**Hills Showground Station Precinct (SSD 9653)  
Request for Additional Information**

I refer to your Response to Submissions for the above Hills Showground Station Precinct (SSD 9653). After careful consideration, the Department requests that you provide additional information to address the issues outlined in **Schedule 1**.

Project	Hills Showground Station Precinct
Drawing Title	Building Heights Plan
Scale	1:2000 @A3

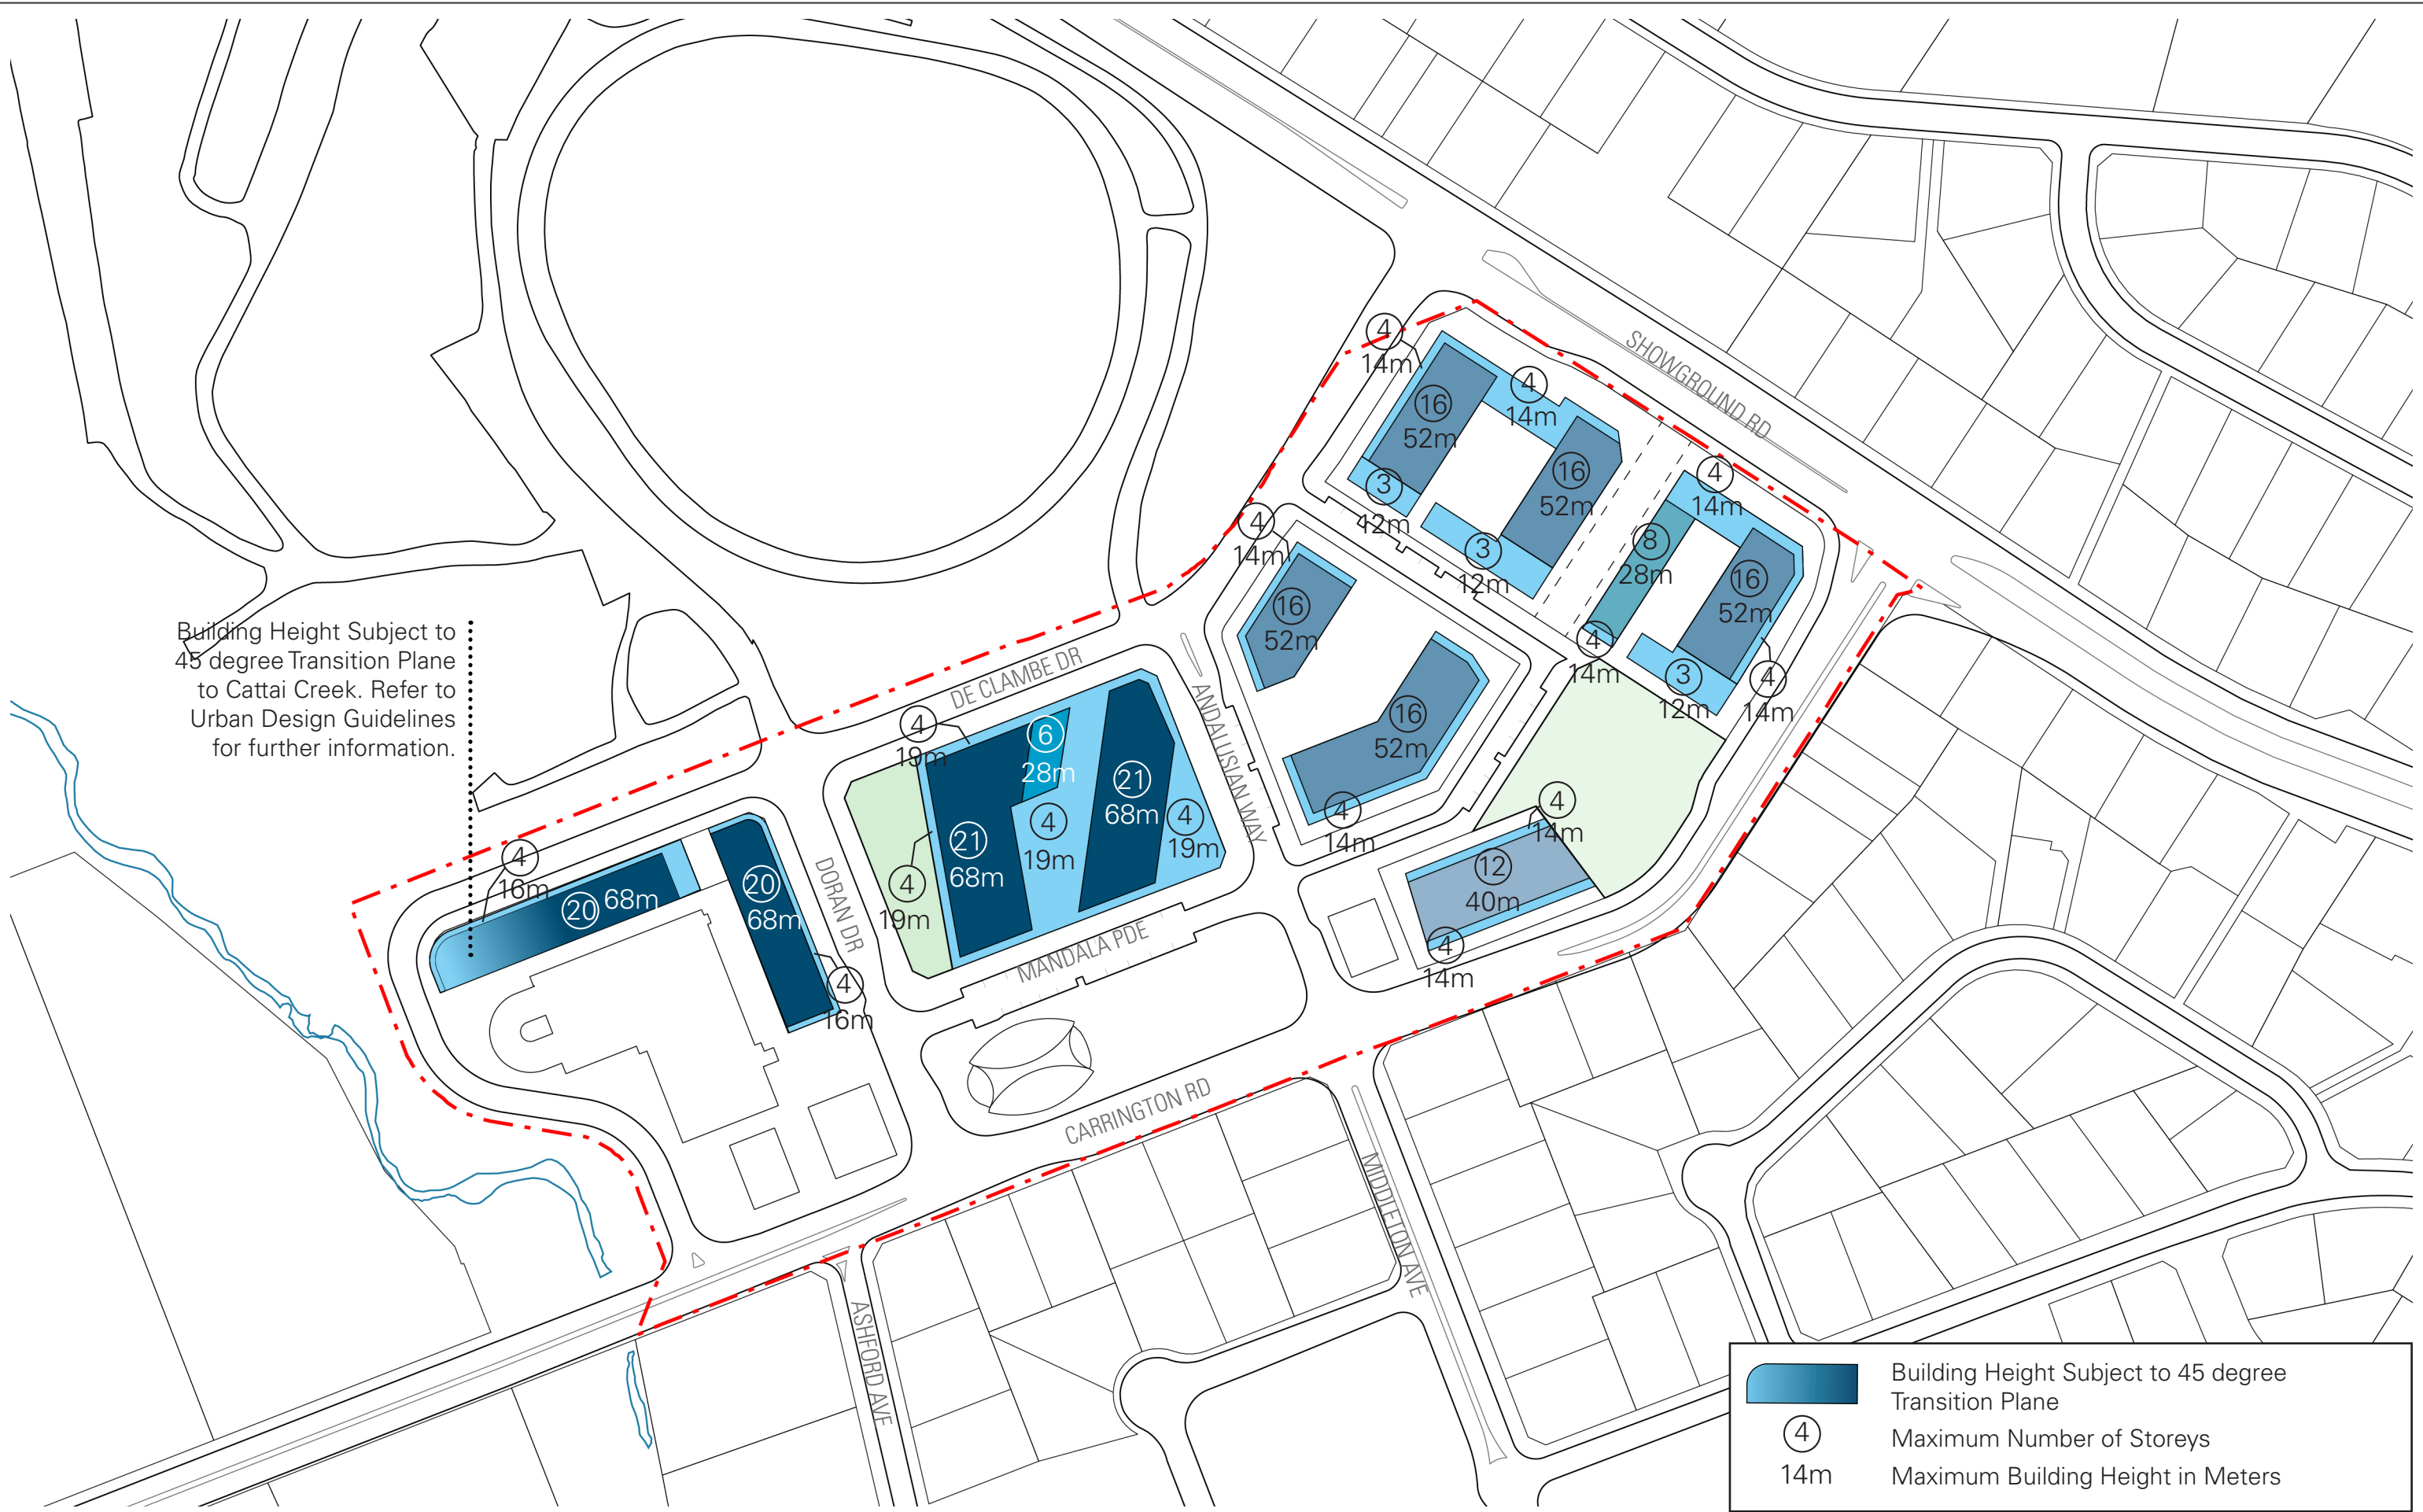
- i. Amend the Building Heights Plan to include both height in storeys and metres to be consistent with the proposed Design Guidelines.
- ii. Clarify how the additional community facilities contribution identified in the Social Infrastructure Report will be secured and the timing of the contribution.

Project	Hills Showground Station Precinct
Drawing Title	Long Section through Doran Drive Precinct and Precinct West
Scale	0 25 75m

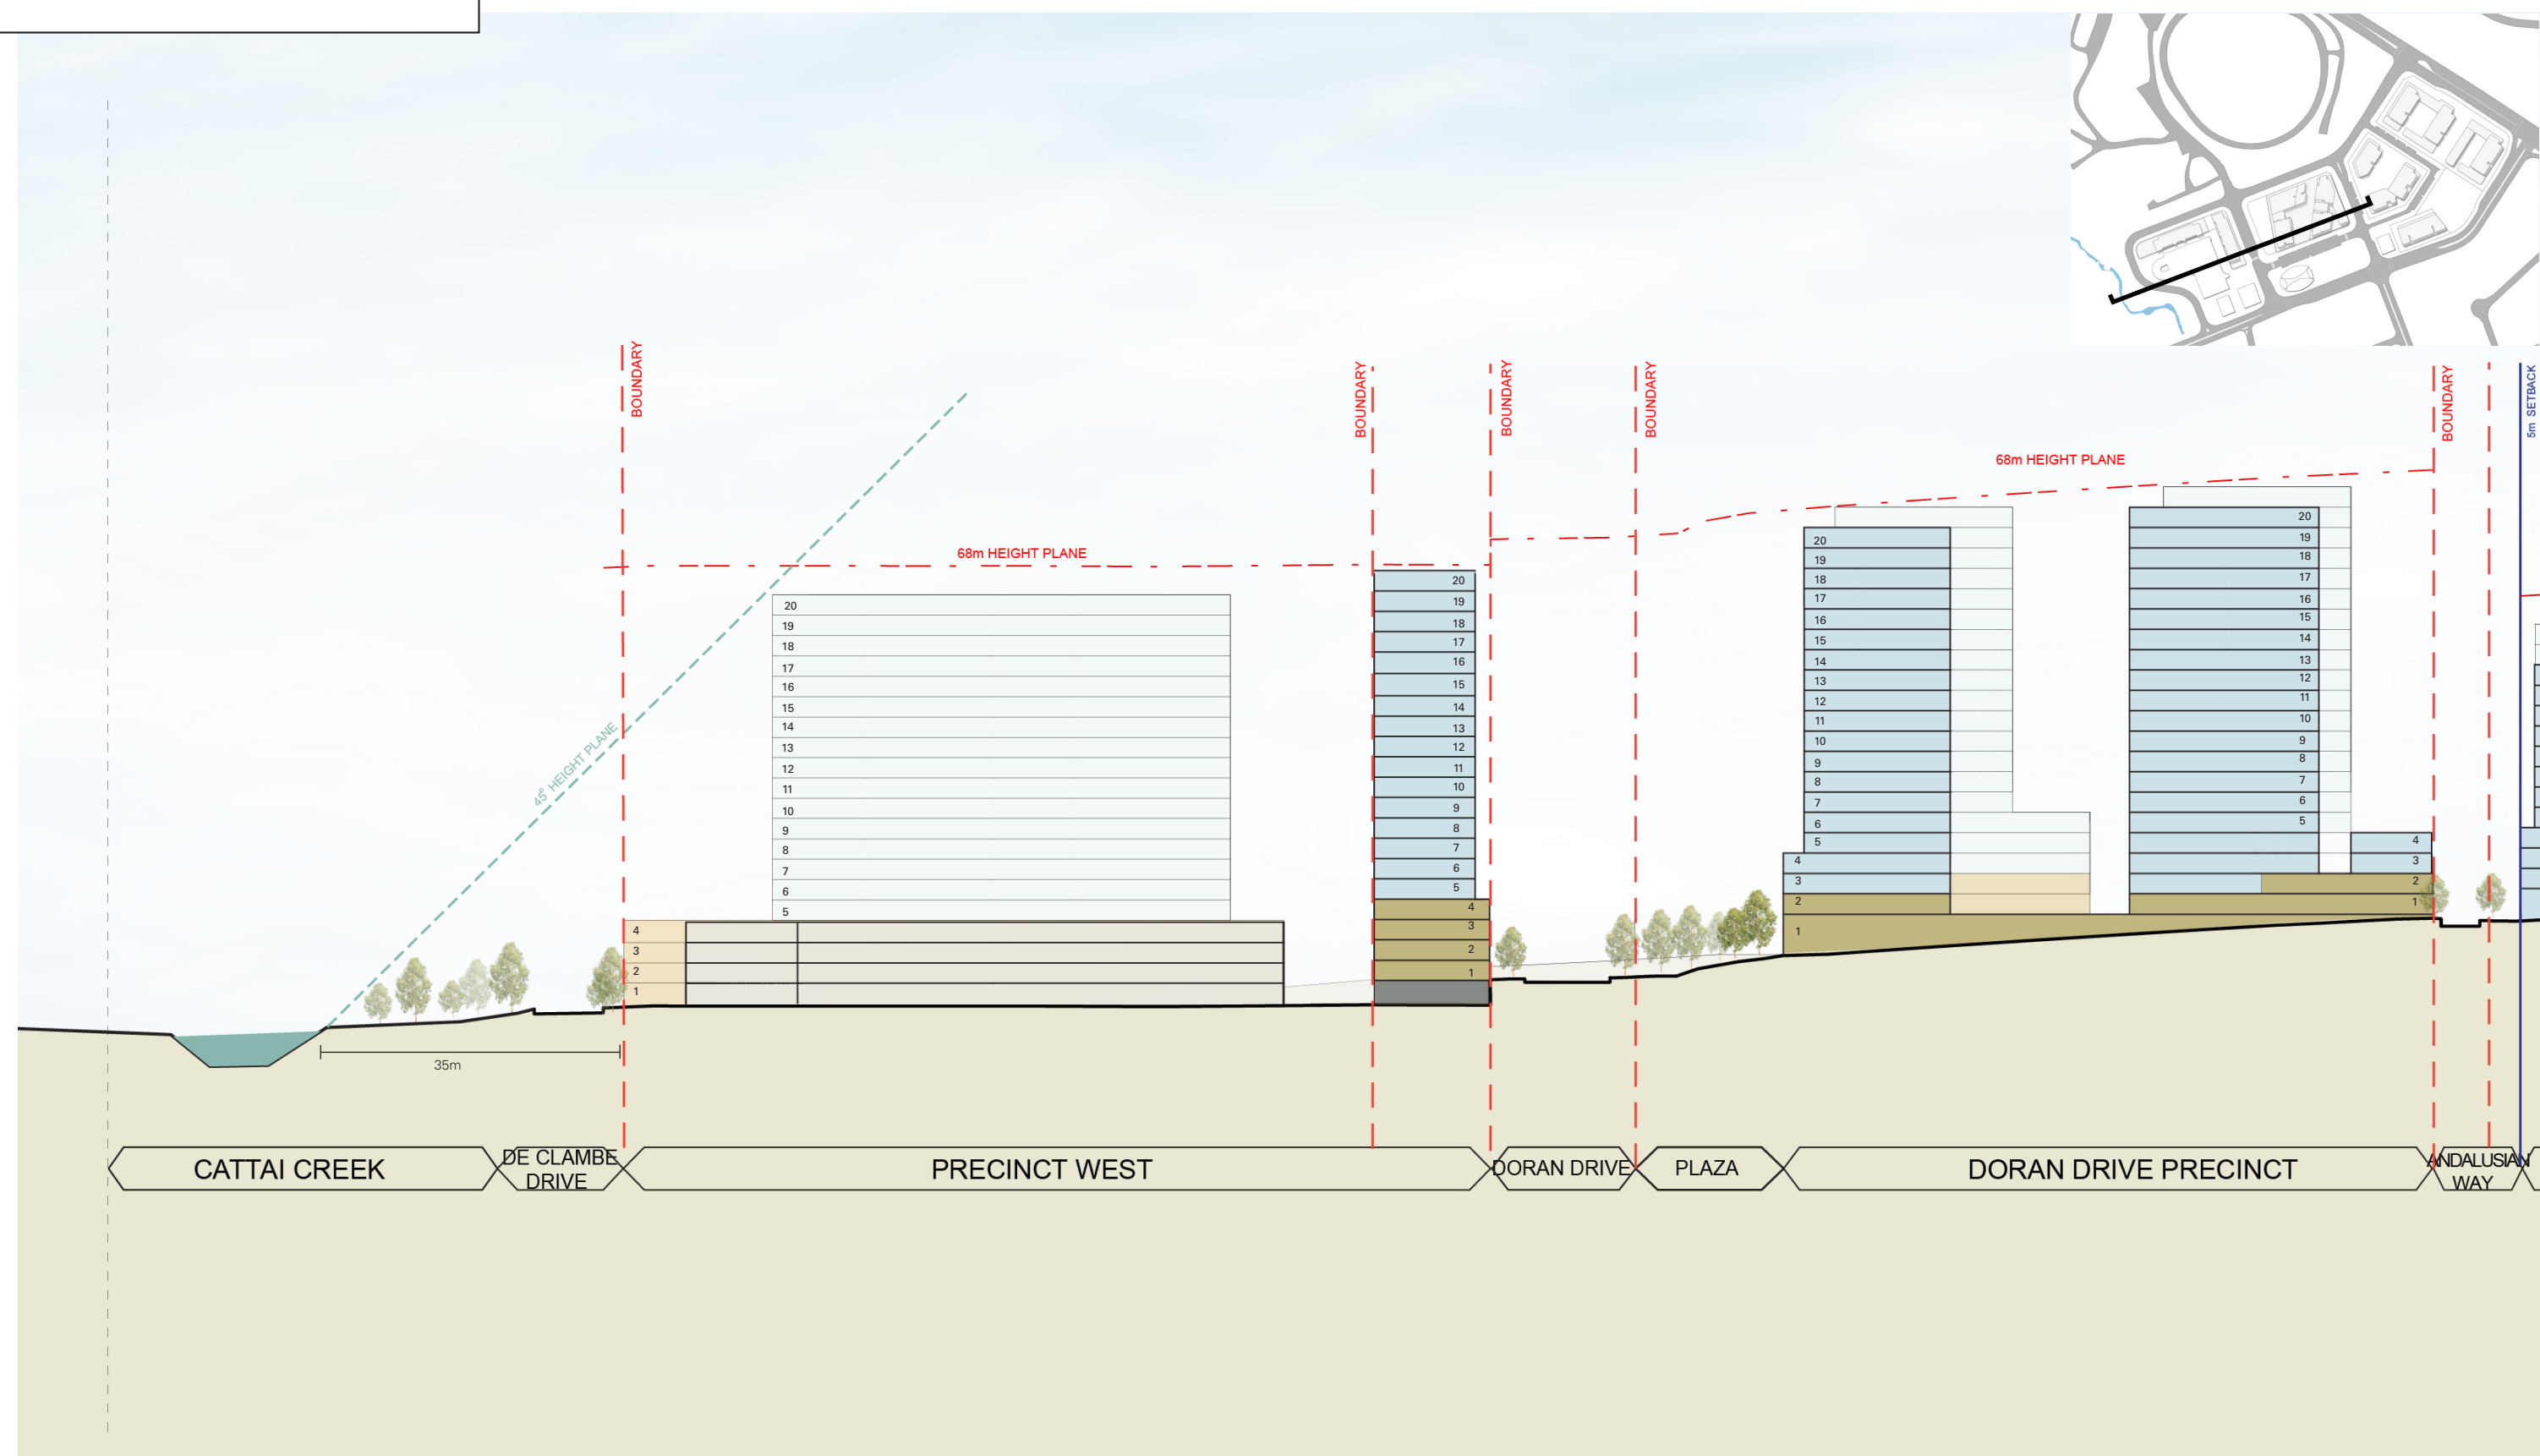
- i. Clarify the discrepancies between the reference to secondary setbacks in the Design Guidelines and the proposed building envelopes, including any projections such as balconies.
- ii. Confirm where the top of the bank is measured from in Part 3.2.6 Control 1.
- iii. Illustrate how the open space to the west of the Metro station can achieve the stated 2 hours of solar access to 80% of the open space.
- iv. Clarify the application of the proposed maximum car parking cap and maximum car parking rates for the proposed housing and commercial uses.
- v. Further consult with TfNSW (RMS) regarding an appropriate car parking rate for the proposal, considering the site's location next to a new Metro Station.
